Catherine-de-Barnes Residents' Association

Response to written and verbal representations made at Deadline 2

1) HE Lighting Technical Note Published 27/6/19

M42 Junction 6 DCO – (scheme TR010027) Document Junction 5A Operational Assessment – published June 2019

Figure 1 - Scheme Layout Plan

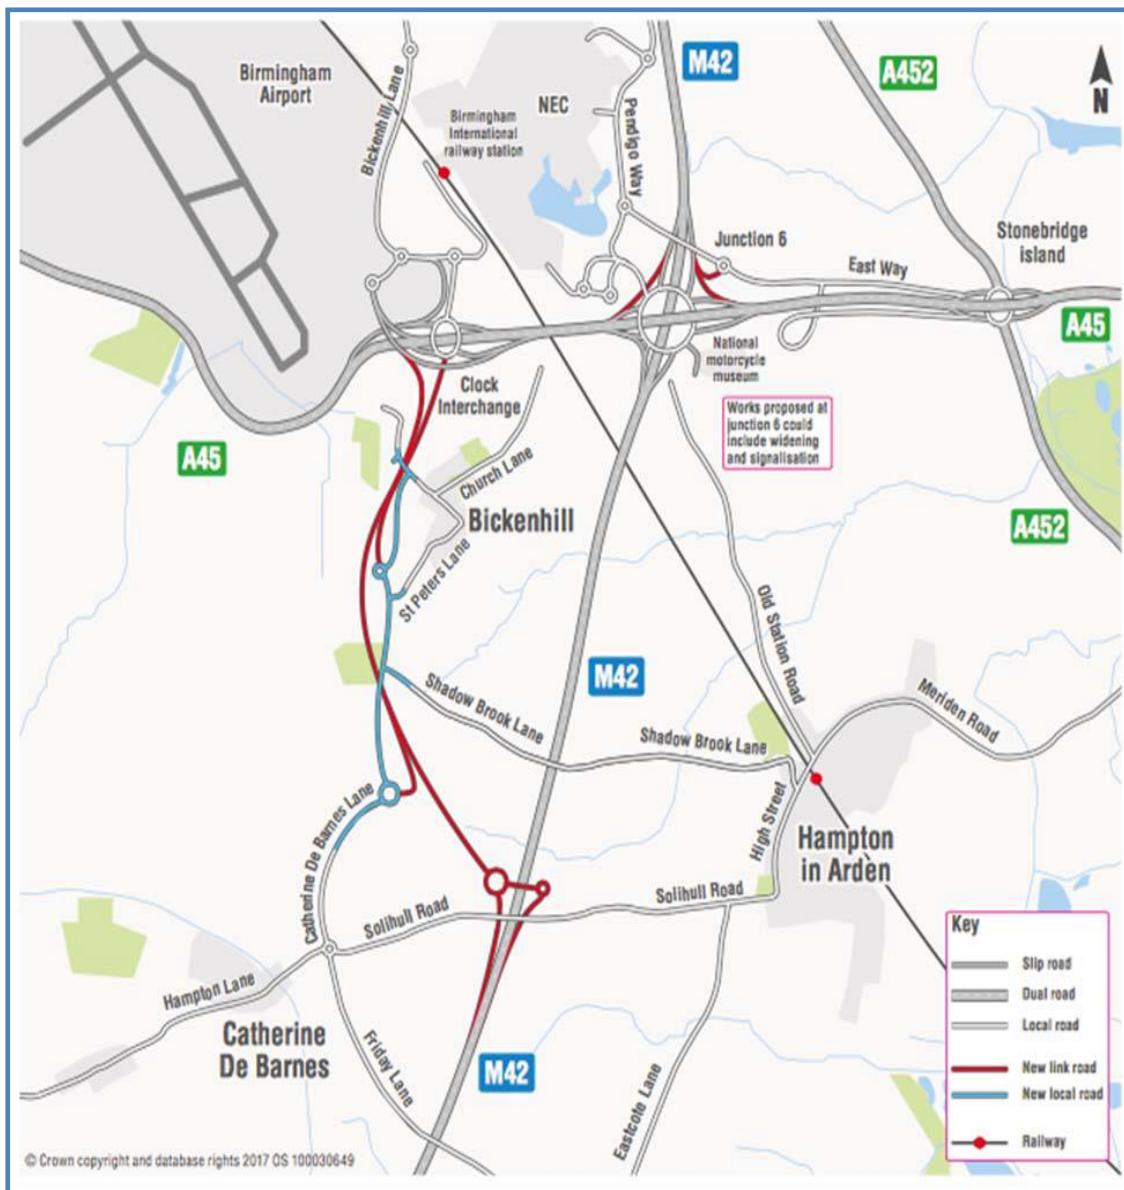
Para2.1.8: No mention is made of any works relating to Catherine de Barnes Lane B4438.

Para 2.1.10: We quote from the document " It is assumed that the alterations to the B4438 Catherine-de-Barnes Lane will not be illuminated, shown in blue in Figure 1. This is to create consistency with the existing local network and to ensure journey quality is not adversely affected for users driving along its length." This is contradicted by the diagram " Road Lighting Sheet 3 of 8 (indicating lighting on the access/exit roads and the roundabout at Barbers Coppice.

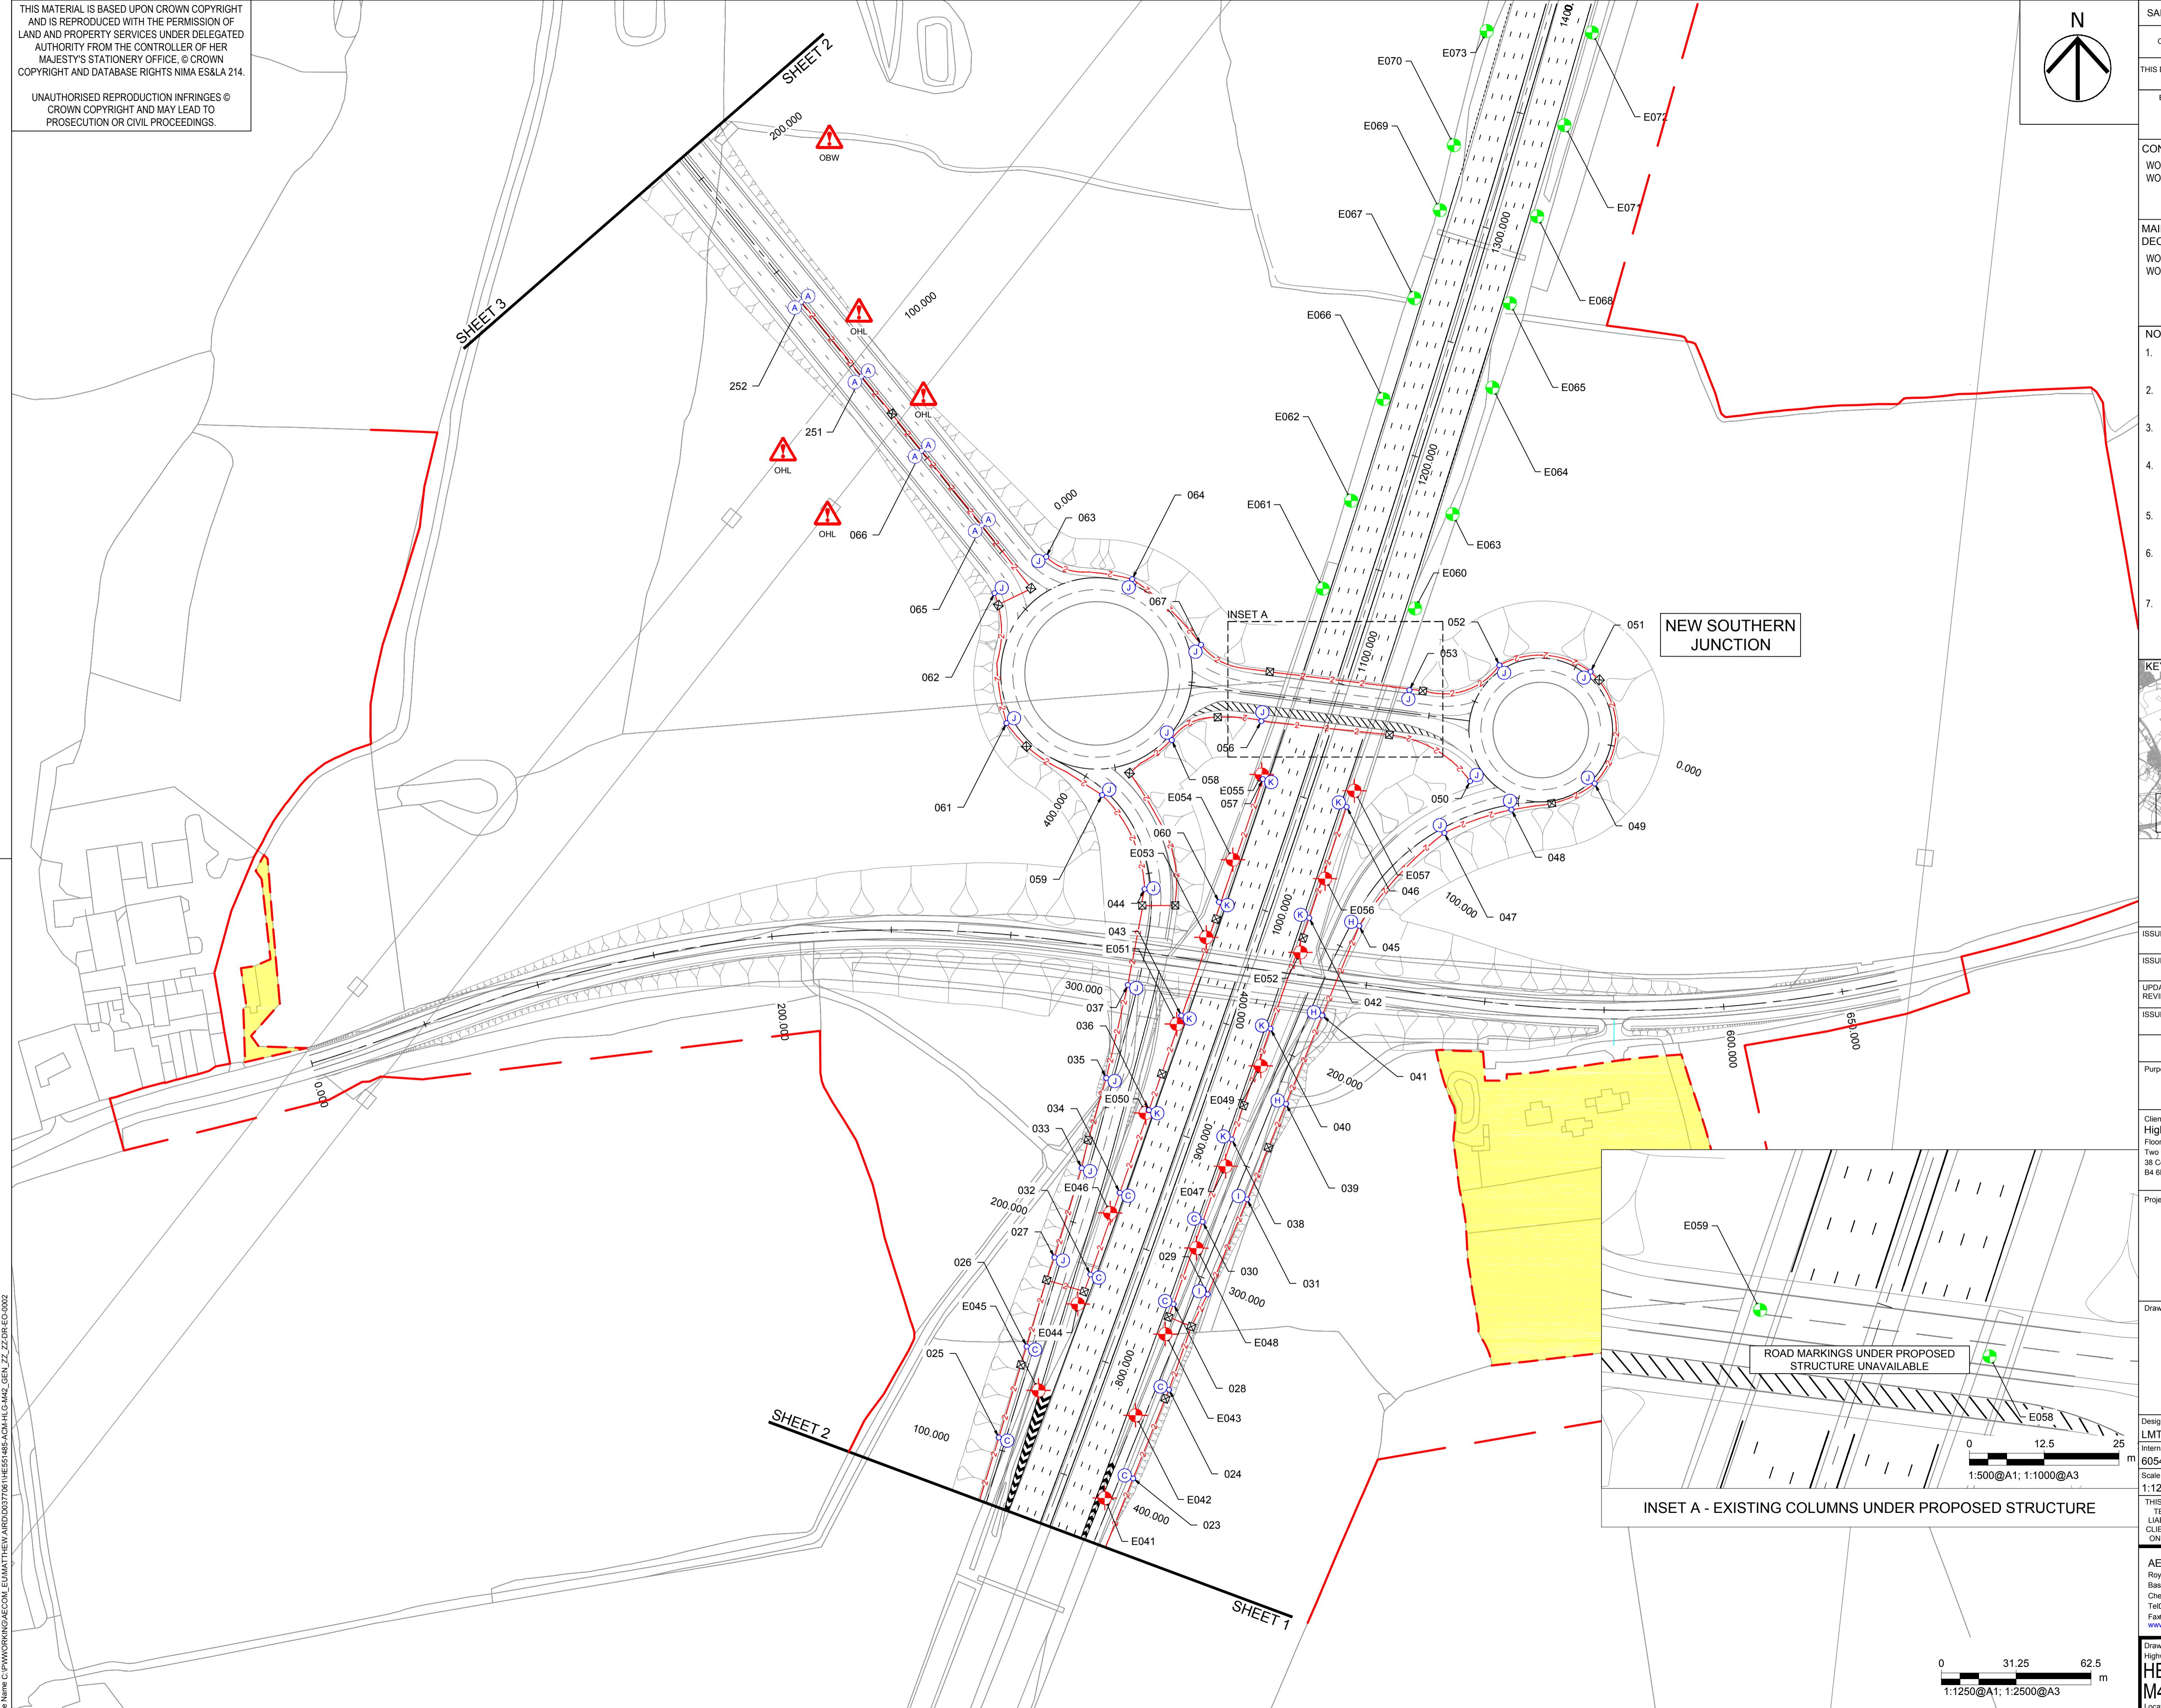
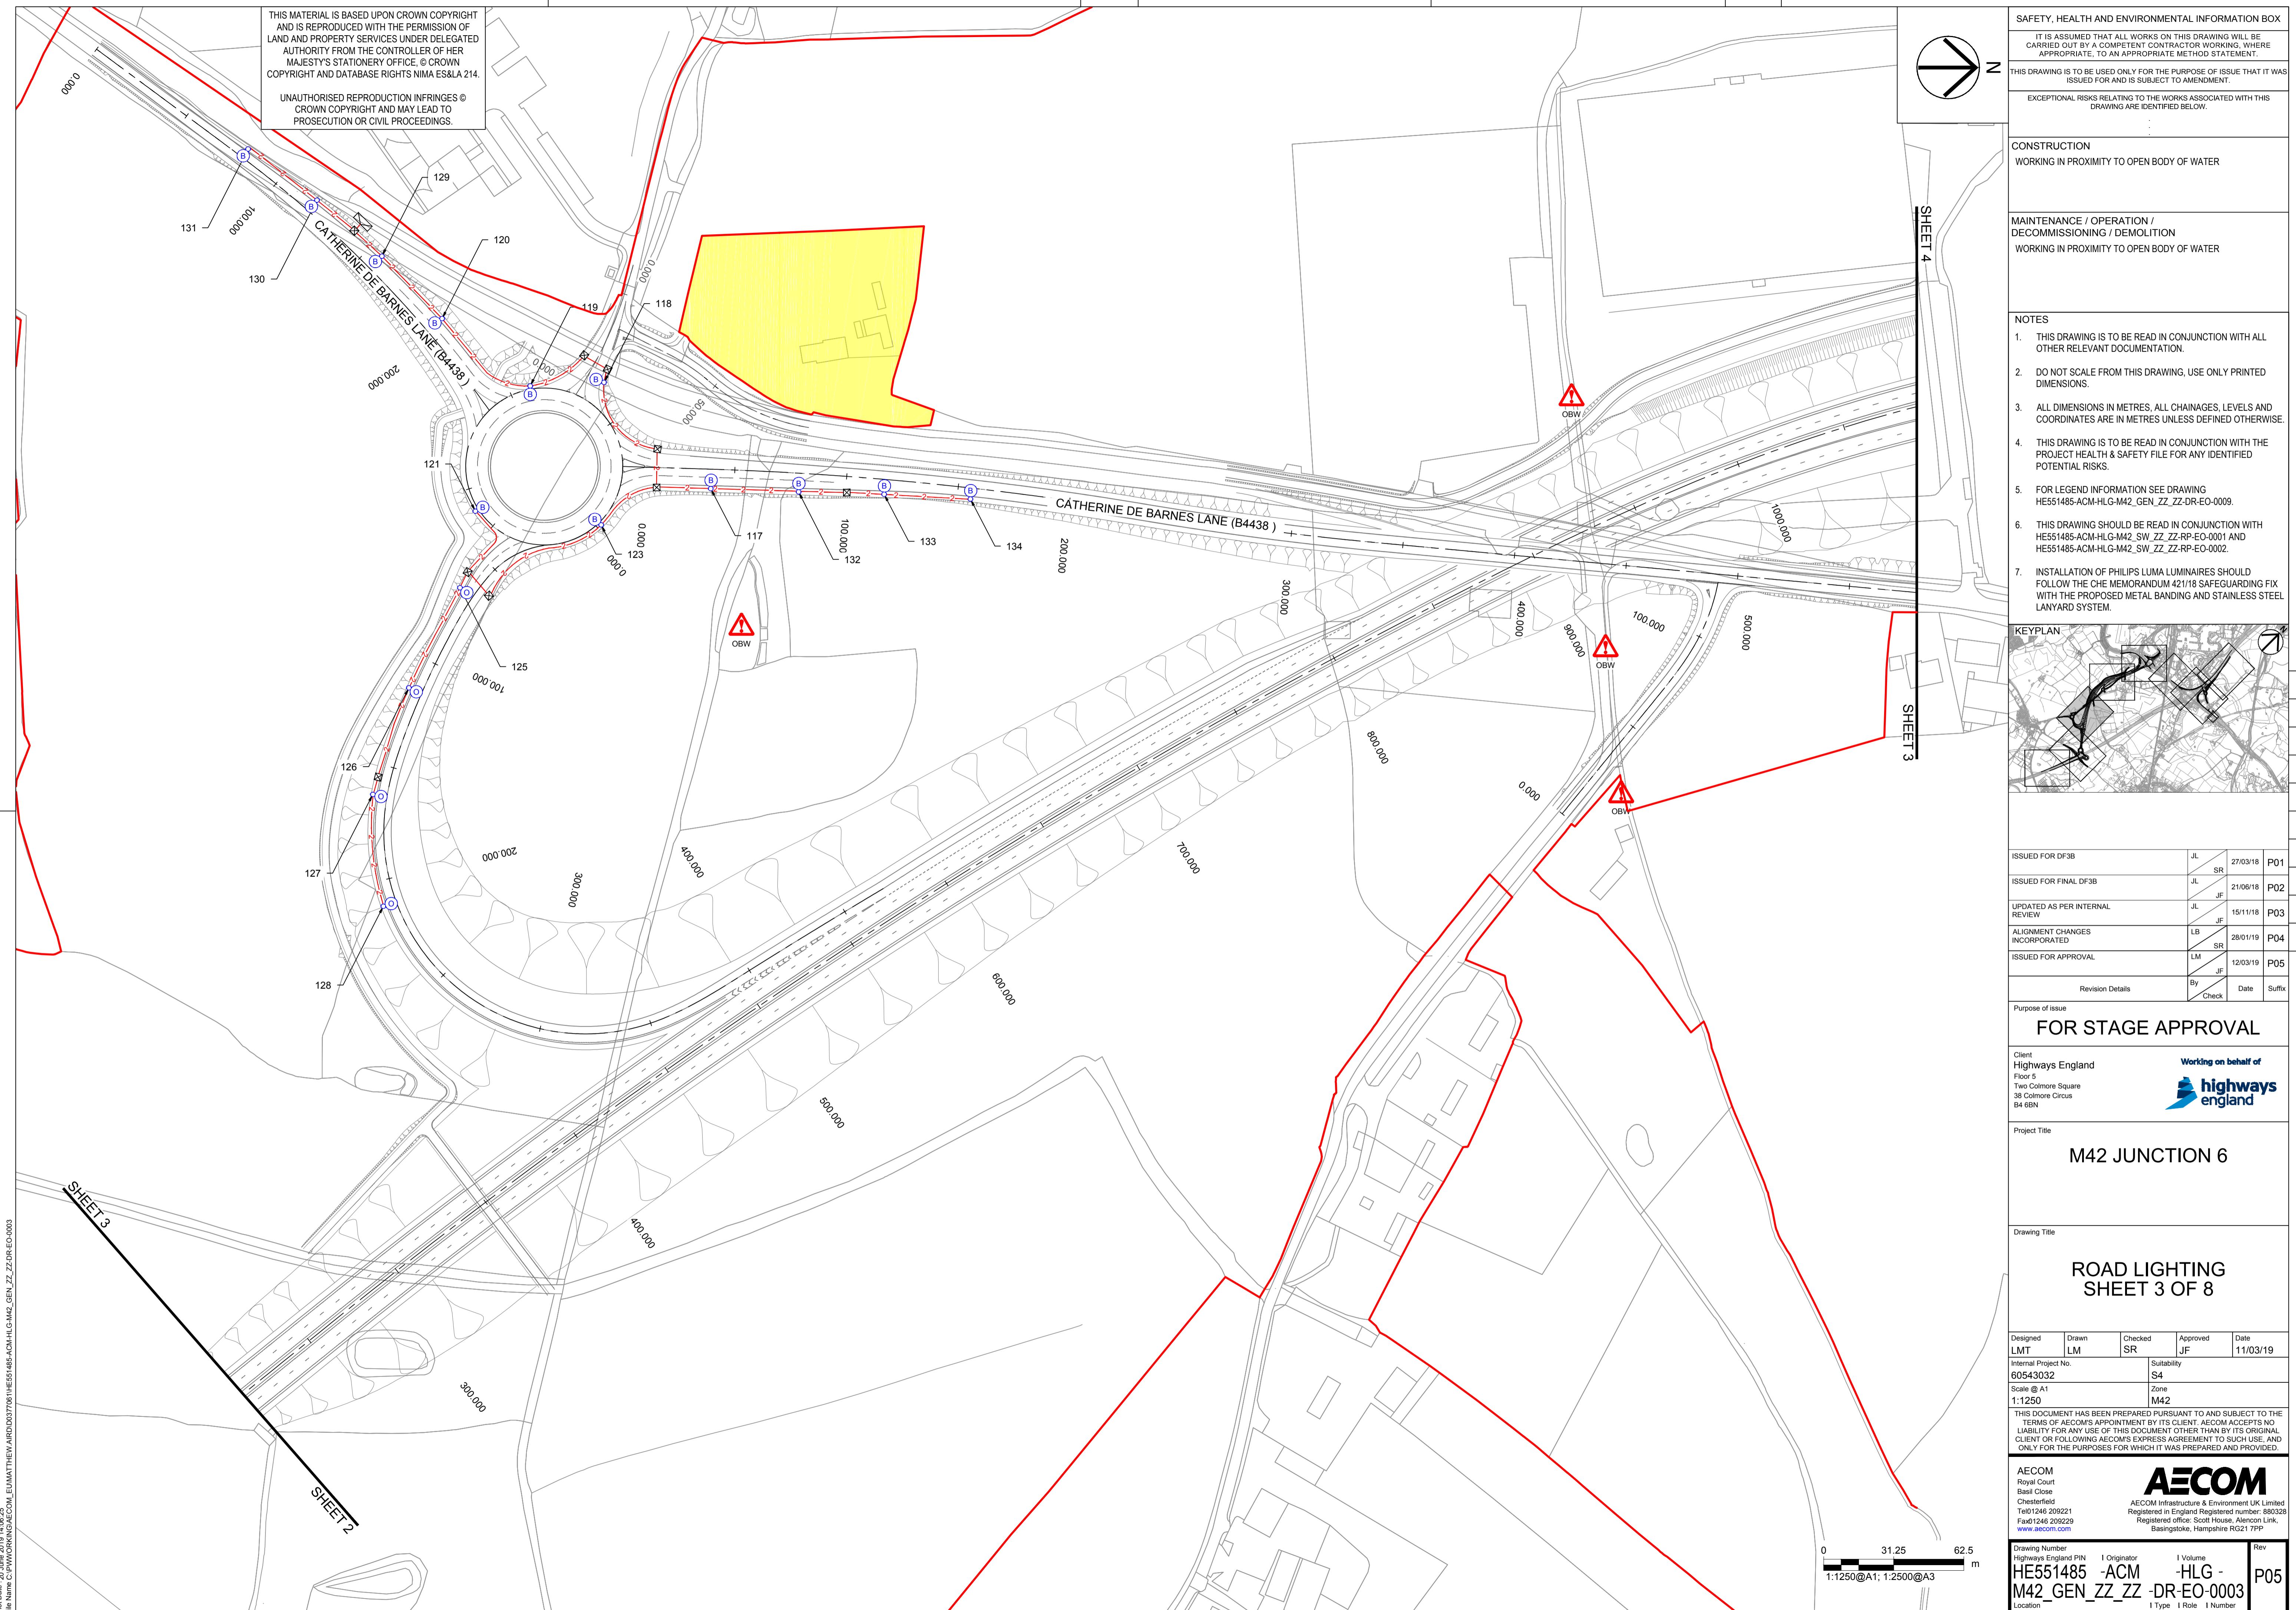
We note that it is the intention to light Barbers Coppice Roundabout and the entry/exits off it but Bickenhill Roundabout and Catherine de Barnes Lane North Overbridge are not to be lit largely because of the environmental /social impact – the surrounding lanes are not lit. Currently Catherine de Barnes Lane (where the Barbers Coppice Roundabout (BCRT)is to be sites) is not lit and we challenge the decision to light it as proposed. From our recollection the speeds of traffic at the BCRT is likely to be 40/50mph but that traffic approaching the Bickenhill Roundabout could be at speeds

of 70mph which would suggest that for safety reasons this roundabout should be lit. The lighting of BCRT severely impact the property of Four Winds. There appears to be further contradiction vis a vis the M42 Southbound Diverge Slip for Jct 6. There will be an apparent saving of 0.13PIA's in year 1 (3 PIA's in yr30) and has a BCR of 2.36 which is described in Table 5 Conclusions and Recommendations – page 17 as a “low BCR” and HE recommends that *“although BCR highlights street lighting is not justifiable for the slip road”* it is recommended for safety reasons.

In comparison Barbers Coppice roundabout will apparently save 0.09PIA's in year1 (2 PIA's in 30 yrs) both figures lower than the M42 Southbound diverge mentioned above. The Coppice Roundabout has a BCR of 2.2, again lower than the slip road mentioned above, yet HE recommends it being lit. There appears to be a distinct lack of consistency and reasoning in arriving at this Lighting Scheme.

The proposed lighting scheme has not been the subject of or included in any public consultation.
